**KIRKLEES METROPOLITAN COUNCIL
INVESTMENT & REGENERATION SERVICE**

DELEGATED DECISION TO DETERMINE PLANNING APPLICATIONS

Reference No:	2022/62/91737/W
Site Address:	416, Bradley Road, Bradley, Huddersfield, HD2 1PS
Description:	Erection of two storey rear extension with roof terrace
Recommending Officer:	Hubert Lam

Officer Report

DRAWING REF :
1972-22-002

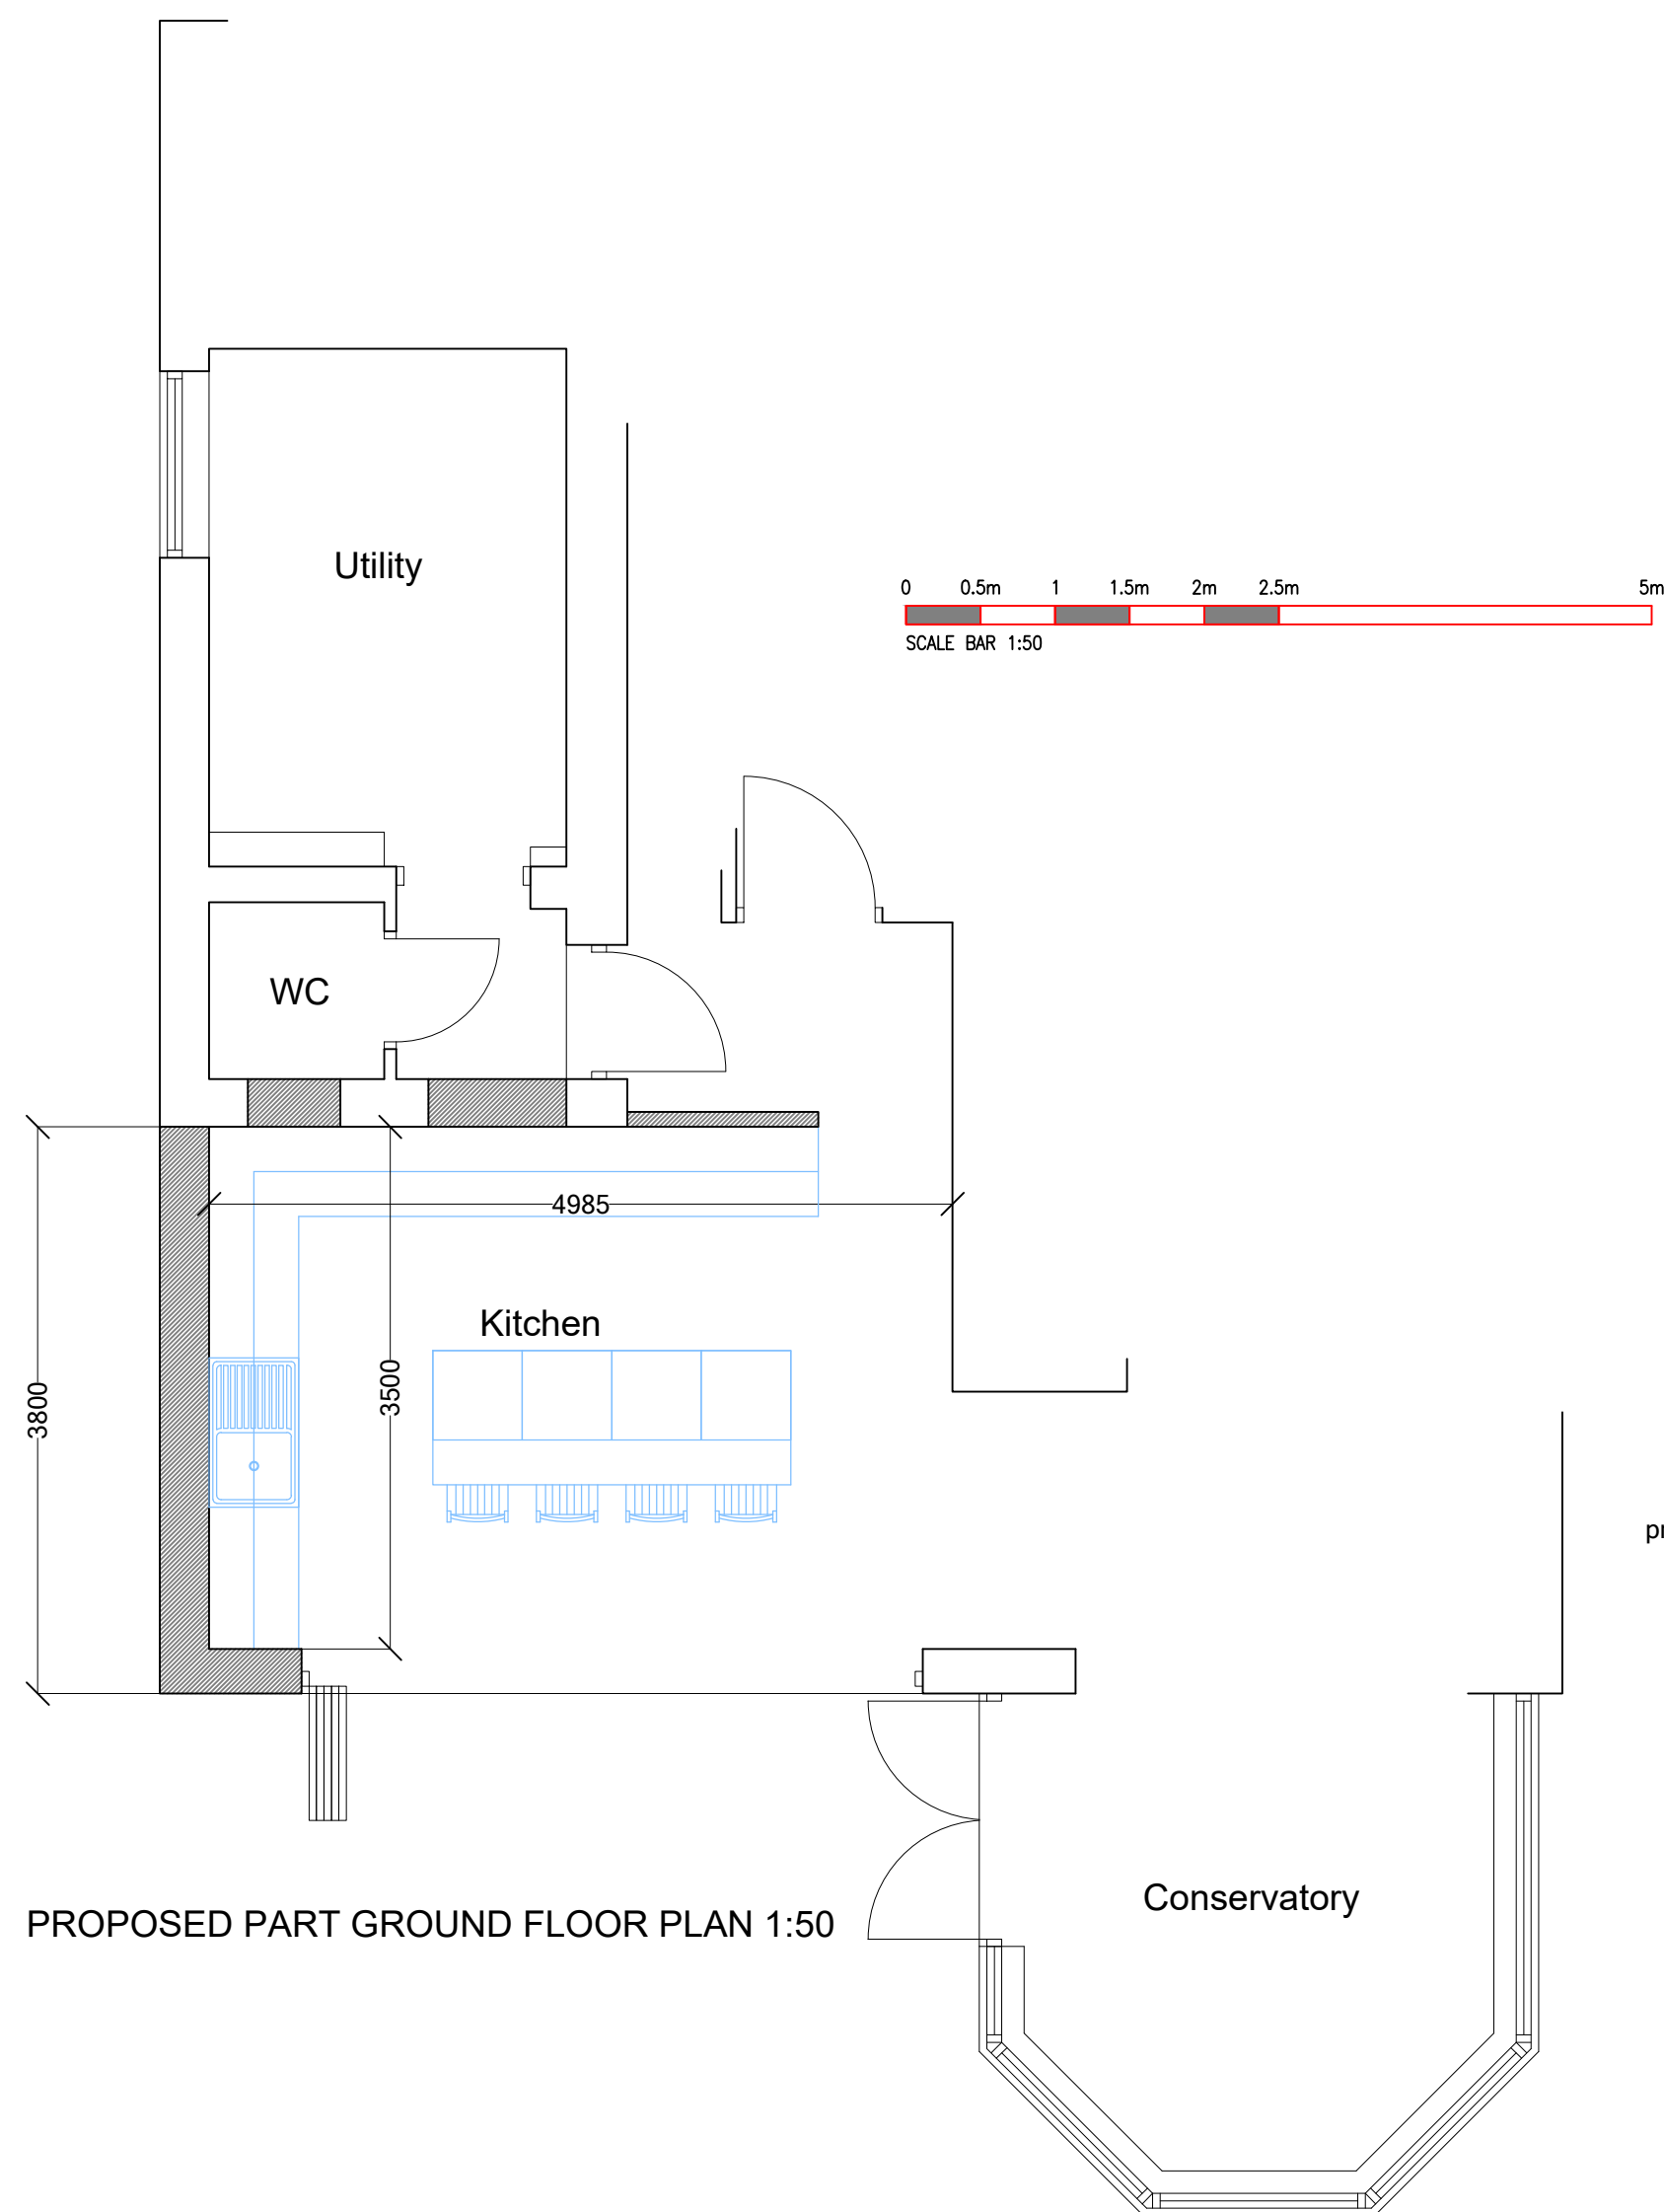
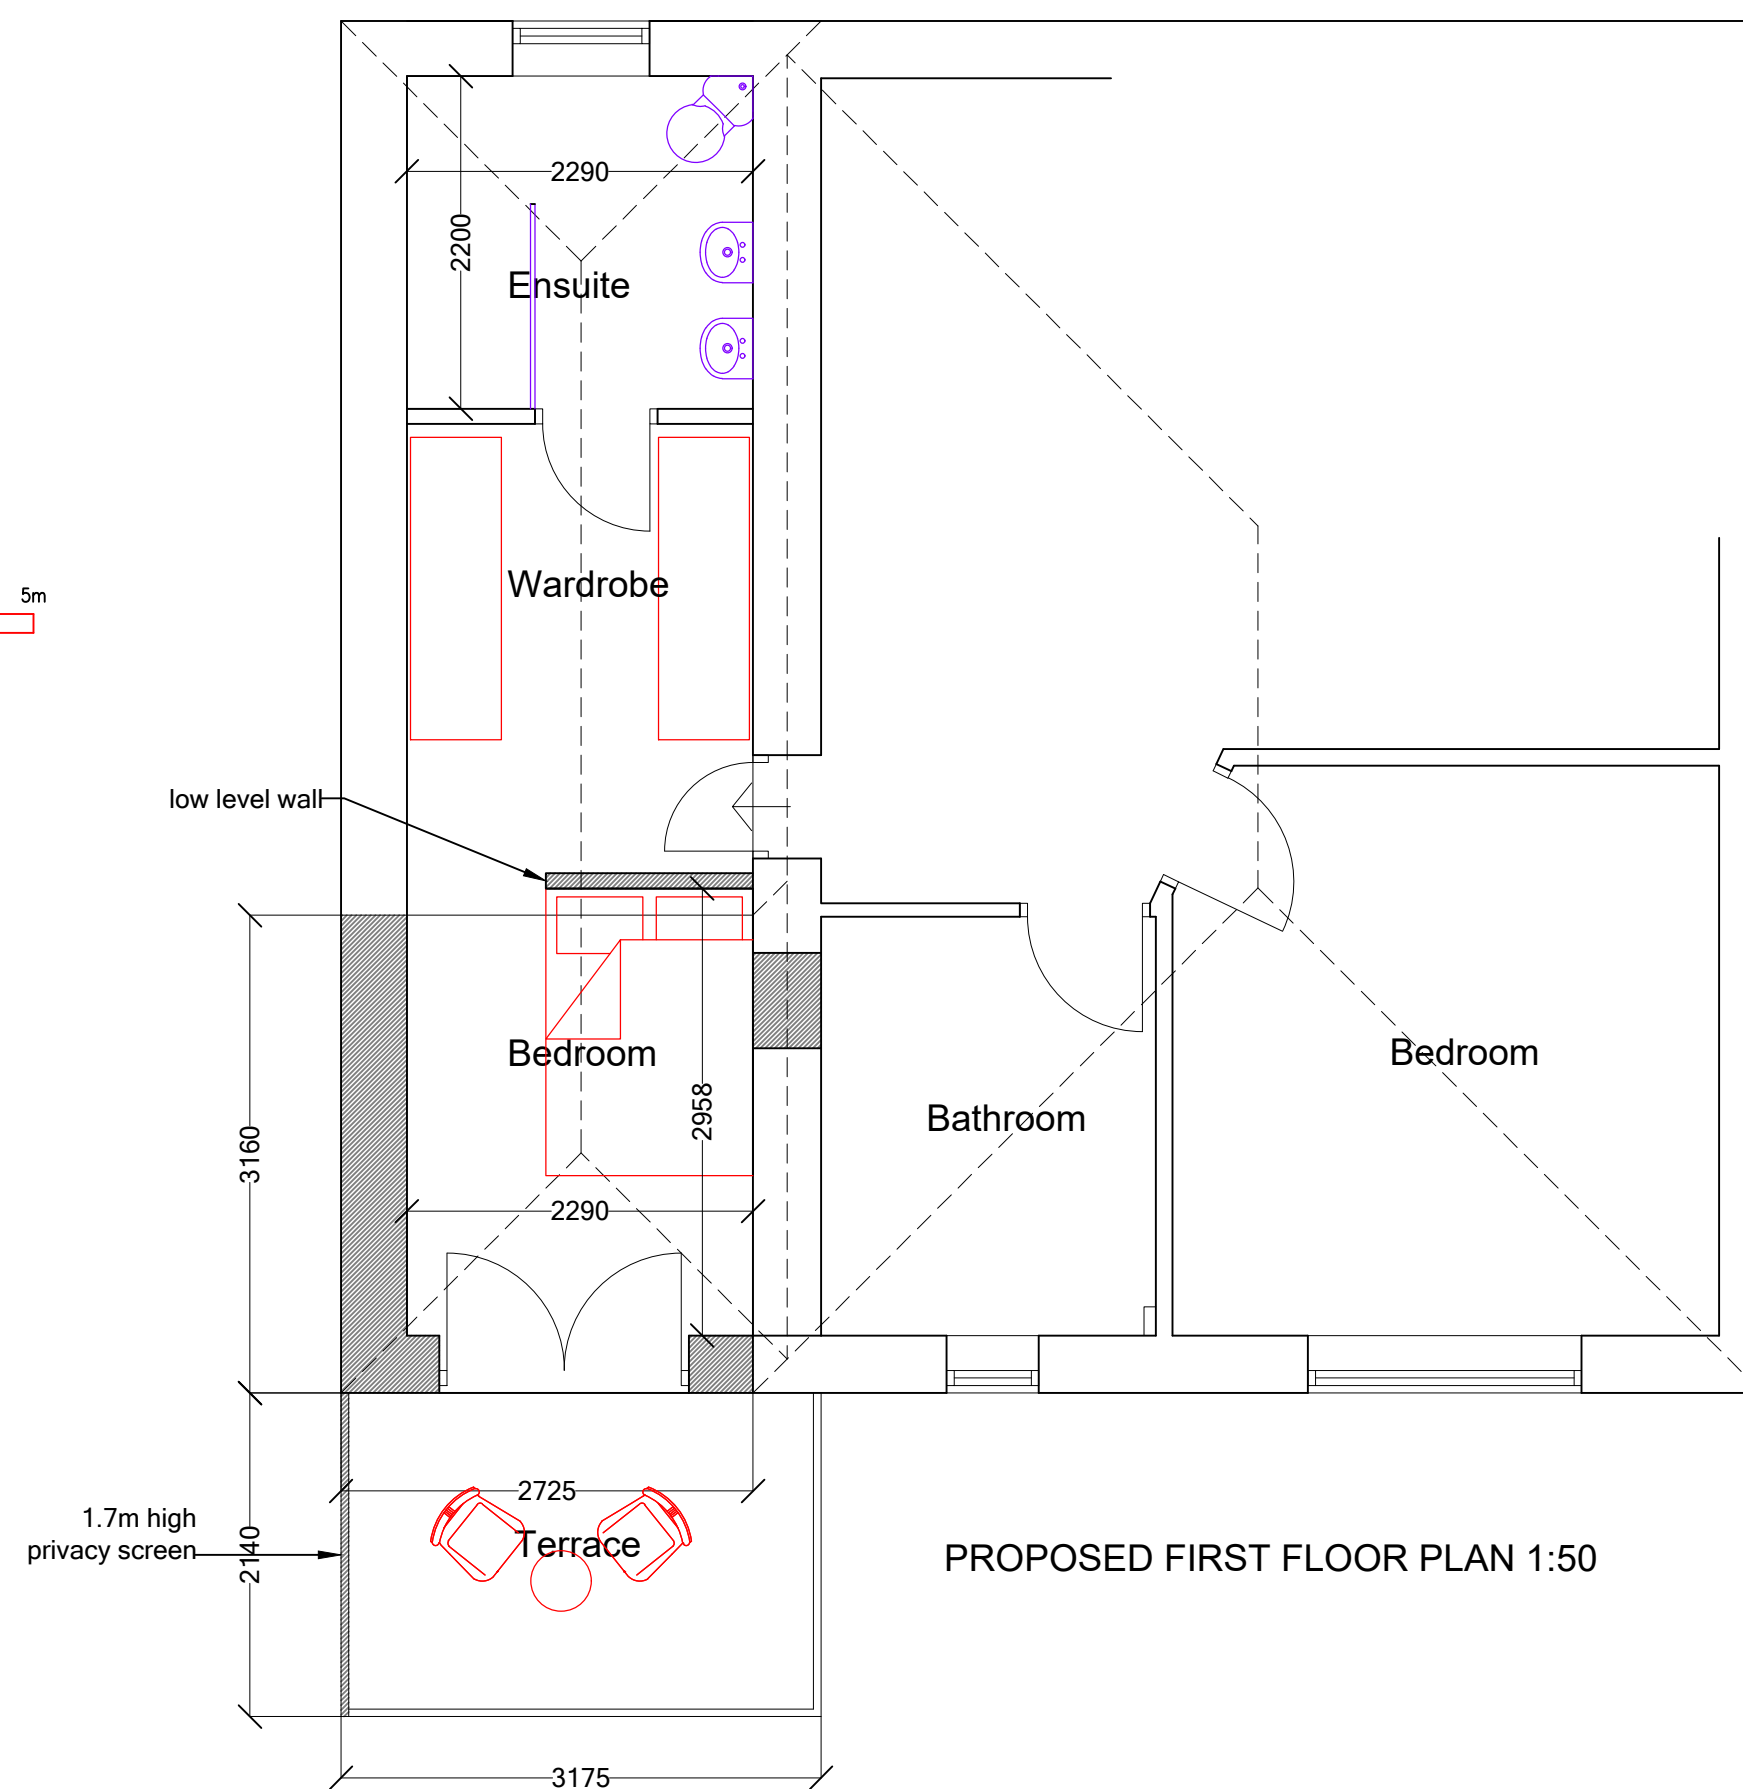
The proposed roof terrace on the first-floor level would utilise the flat roof section of the ground floor level and have a floor area of 2140mm in length and 3175mm in width, delineated on its side elevations by obscure glazing (privacy screen) at a height of 1.7m. This would prevent the direct overlooking of private amenity spaces. In addition, no. 414 has a rear extension that projects much further than this terrace area and the terrace is set some distance way from no. 418. As such, subject to the condition securing the installation of obscure glazing to the privacy screens notwithstanding the plans as submitted, this roof terrace element would not pose a greater privacy impact on the neighbours than that of the existing house in this respect and would accord with Paragraph 5.28 of the SPD specifically regarding the assessment of roof terraces and balconies.

4. Notwithstanding the plans submitted, the roof terrace hereby approved shall not be brought into use until obscure glazing of a minimum grade 4 has been installed to the privacy screens proposed to the eastern and western sides of the roof terrace. The obscure glazing shall be 1.7m in height, either in total or in cumulative height with solid walling. The obscure glazing shall be thereafter retained.
